CITY OF ALBUQUERQUE

June 19, 2012

Re: Central Appliance Storage Addition, 4806 Central Avenue SW,
Traffic Circulation Layout
Engineer's Stamp dated 09-01-11 (K12-D031)

Traffic Circulation Plan

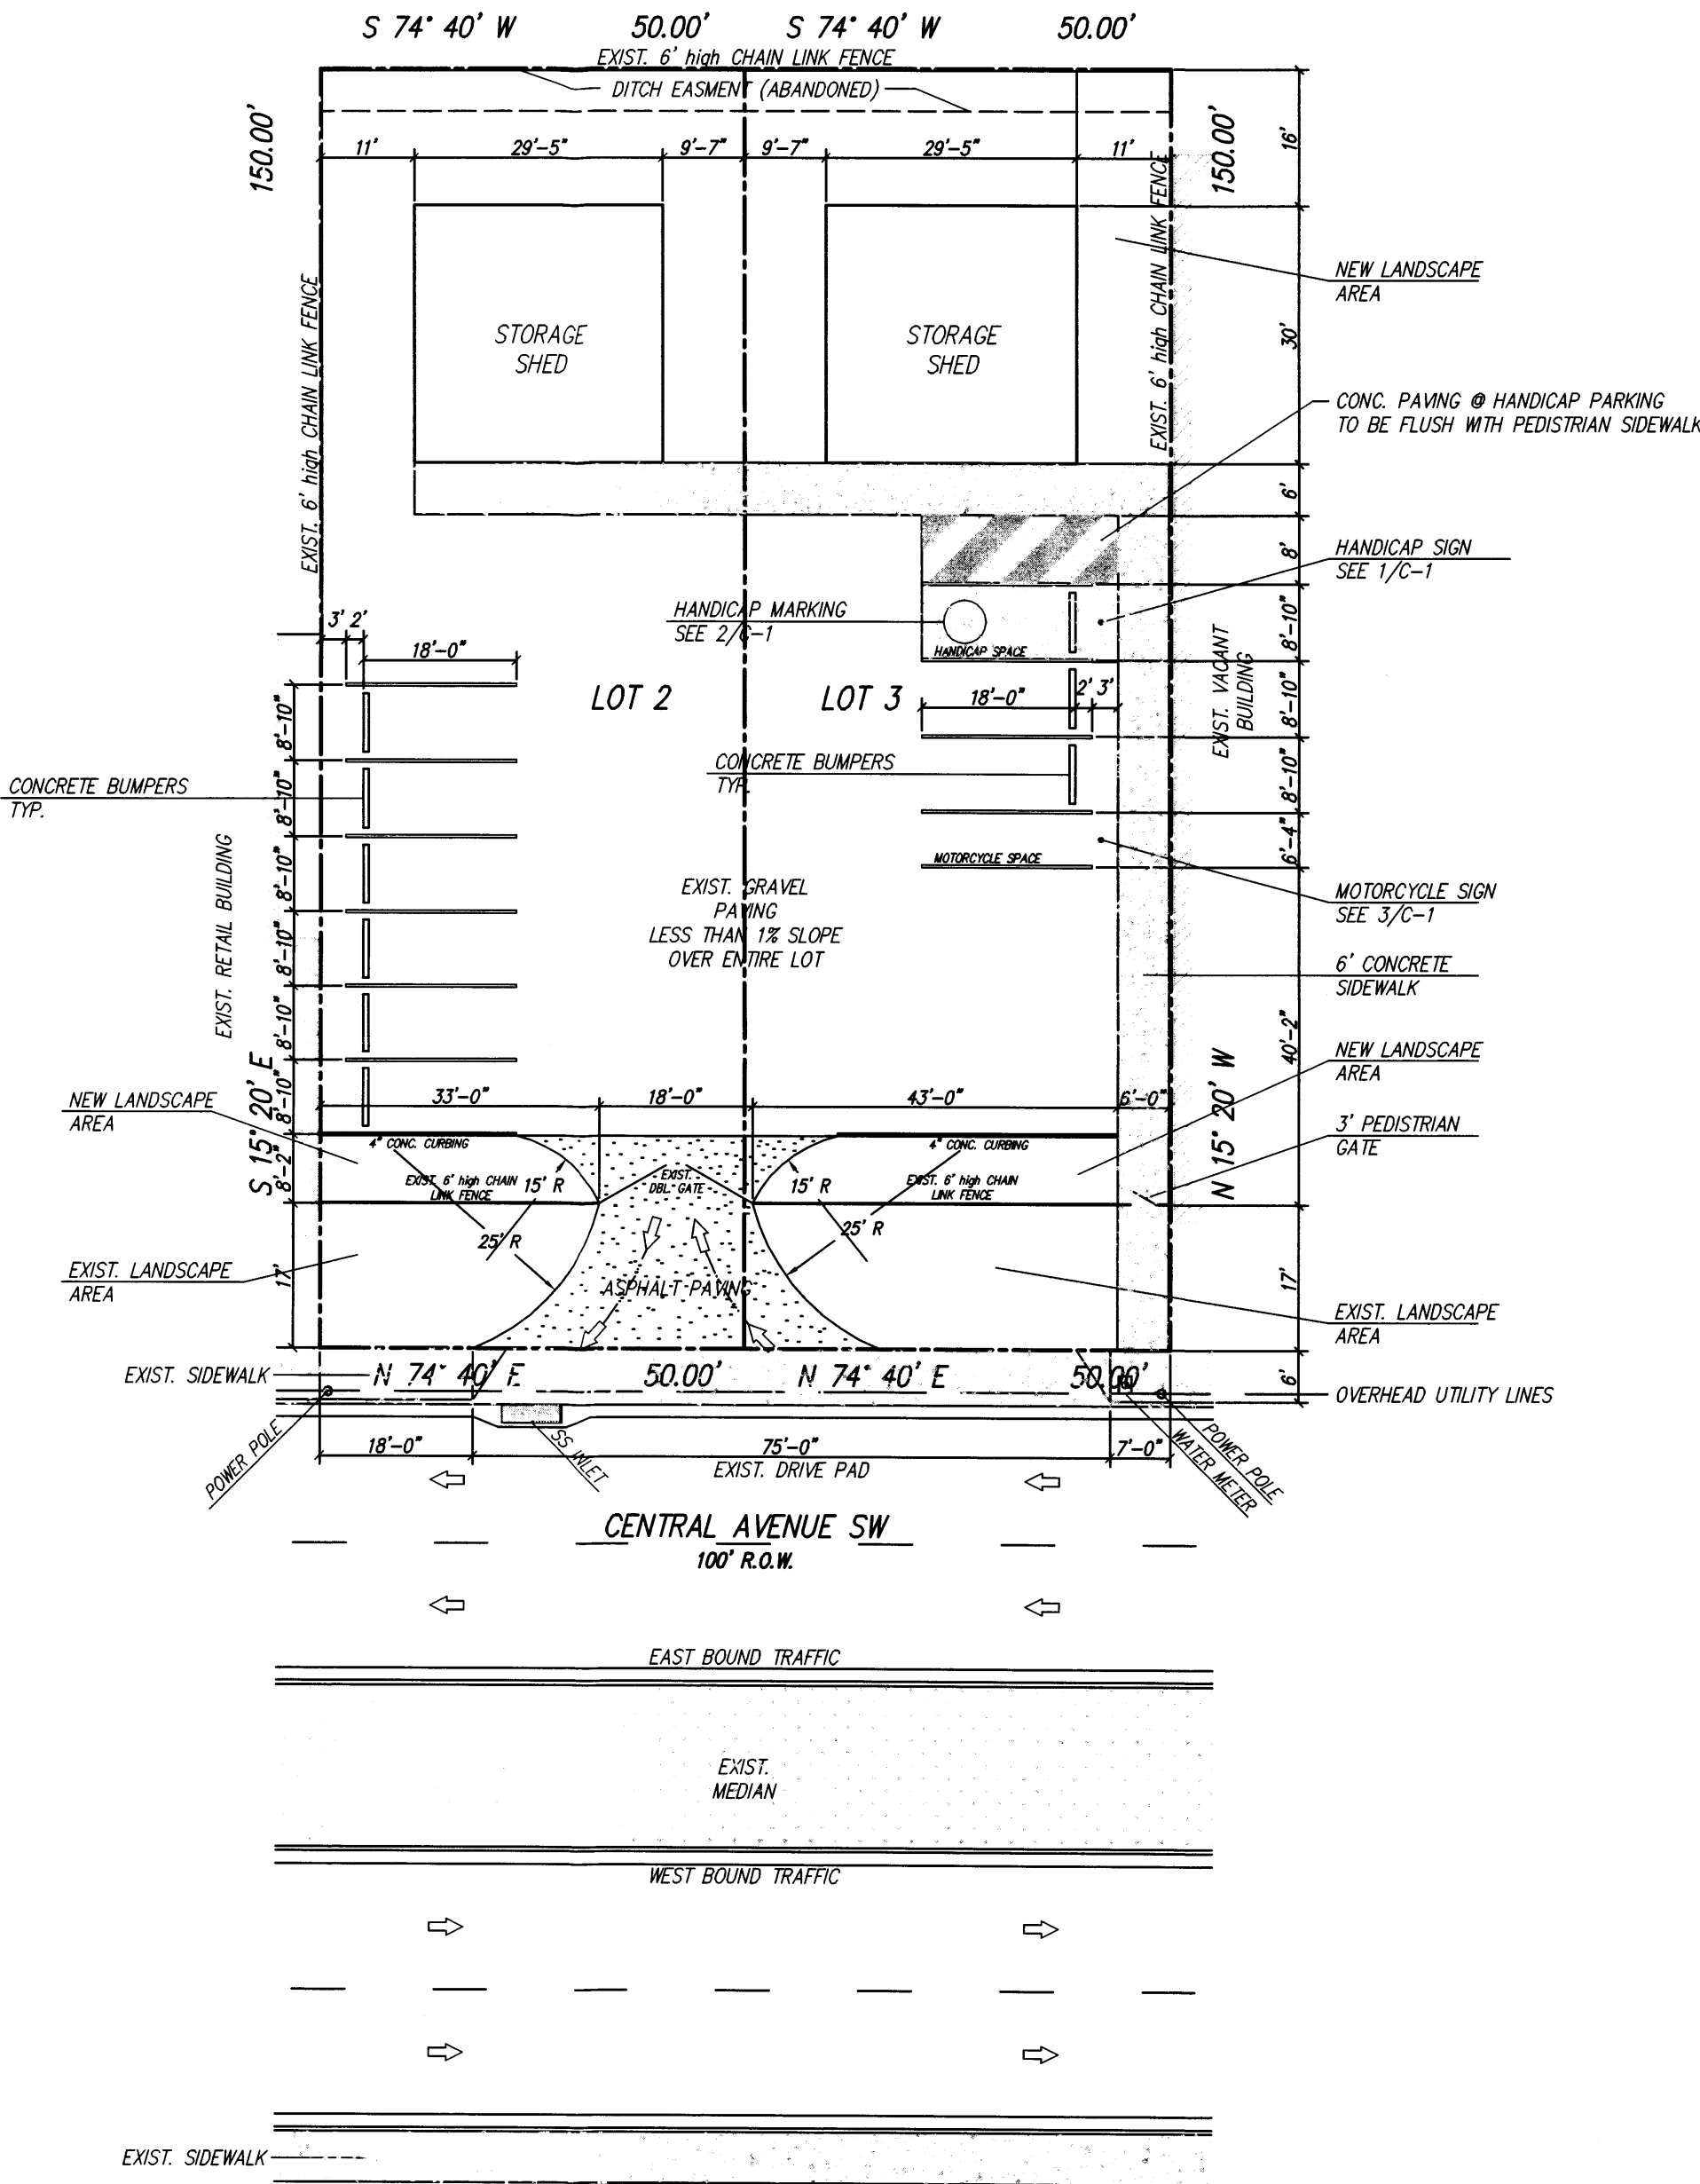
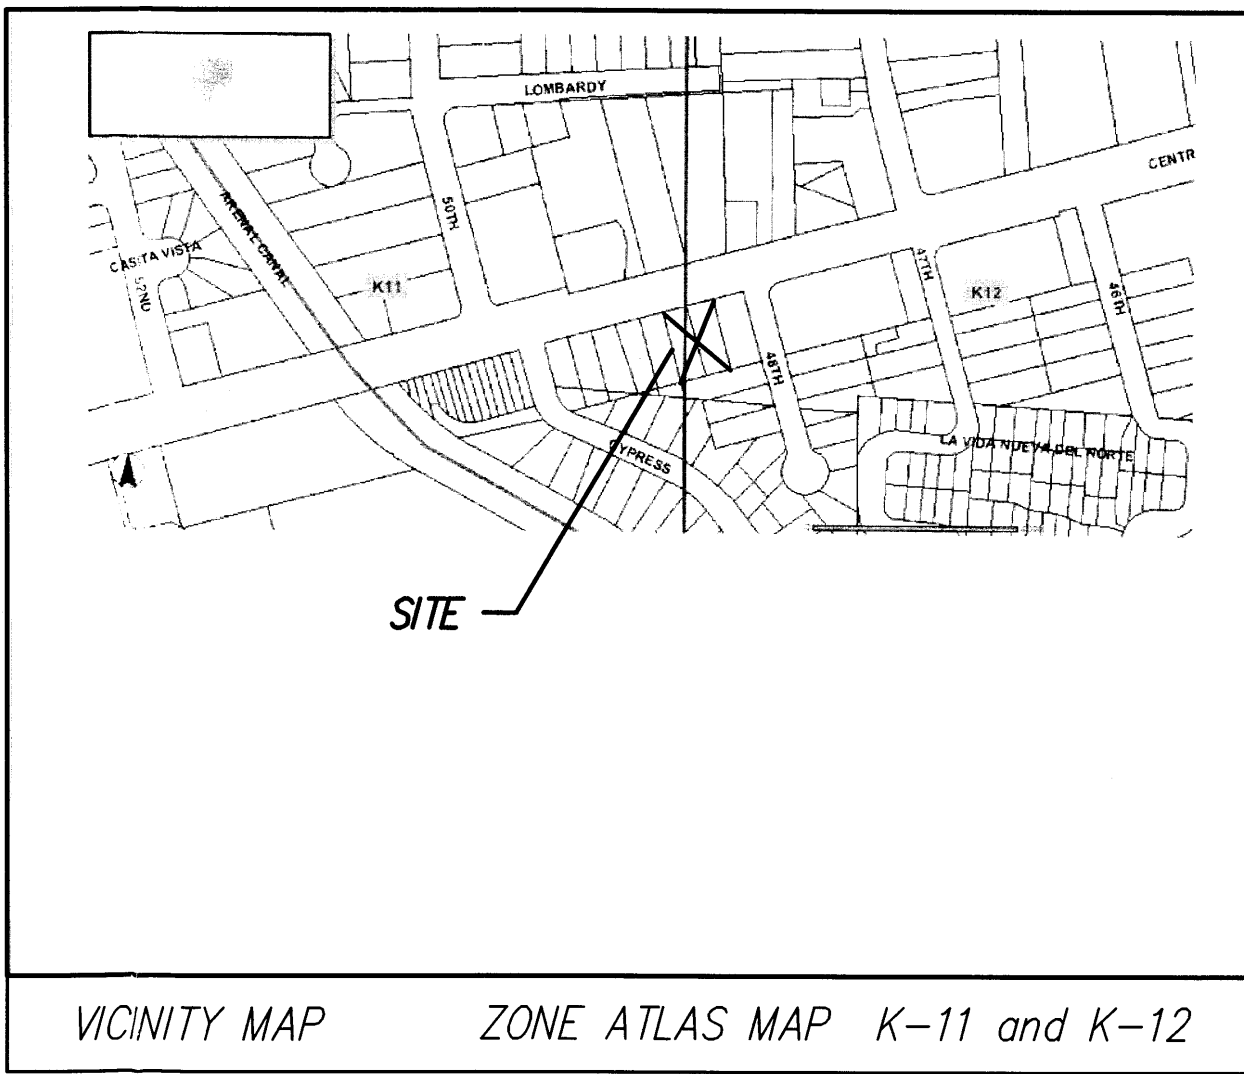
- **A recorded copy of the cross access easement between lots 2 and 3 must be provided.**
